**Application by Thurrock Power Limited for an Order
granting Development Consent for the Thurrock Flexible Generation Plant**

Planning Inspectorate Reference: EN010092

DEADLINE 4 SUBMISSION

PoTLL/TFGP/EX/8

Figure 1.1 Proposed causeway structure.

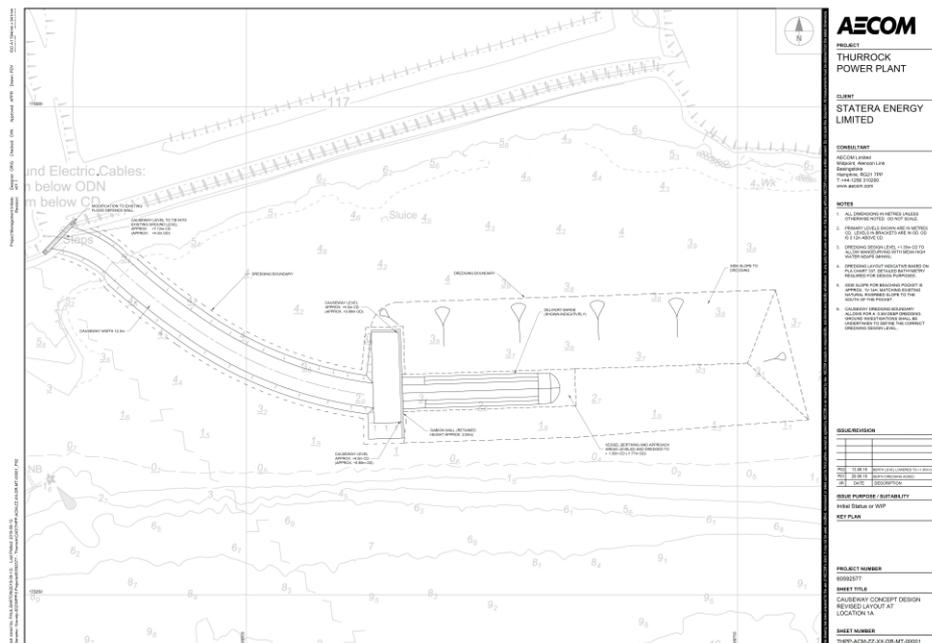
Executive Summary of Key Findings of the High-level Geotechnical Assessment	
1.	A site investigation comprising a desk study and ground investigation has not been carried out for the proposed causeway and berthing area. A desk study and detailed ground investigation will be required to provide appropriate geotechnical and geoenvironmental parameters for the design of the causeway and berthing area. The present conceptual design provided by AECOM can only be considered as conjectural and lacks specific data to justify feasibility and allow proper engineering scrutiny.

2.	There is no detailed bathymetrical survey data for the causeway and berthing area. Without such a survey it may not be feasible to site the causeway and berthing area in the proposed location.

3.	The current design has not accounted for flood tides, cross currents and wave loads in relation to the long-term stability of the causeway and berthing area. Without this information it is not considered that a feasible conceptual design can be undertaken for the proposed causeway and berthing area.

7. It is clear from the conceptual design report that there is currently no understanding of the ground conditions, geotechnical properties and engineering behaviour of the intertidal and estuarine deposits. The current conceptual design can only be viewed as conjectural and lacks engineering rigour to justify the proposed design concepts.

9. The current assumption to construct 1:3 side slopes for the causeway is questioned by AECOM, the concept designer. There is currently no ground investigation data to justify whether these slope gradients can be constructed at all. As there is no geotechnical data available no stability analyses can be carried out to support the conceptual design of the causeway side slopes.

10. No geotechnical data or geotechnical analyses are provided in the conceptual design report to support the design of the gabion wall and crane pads to be located at the end of the causeway.
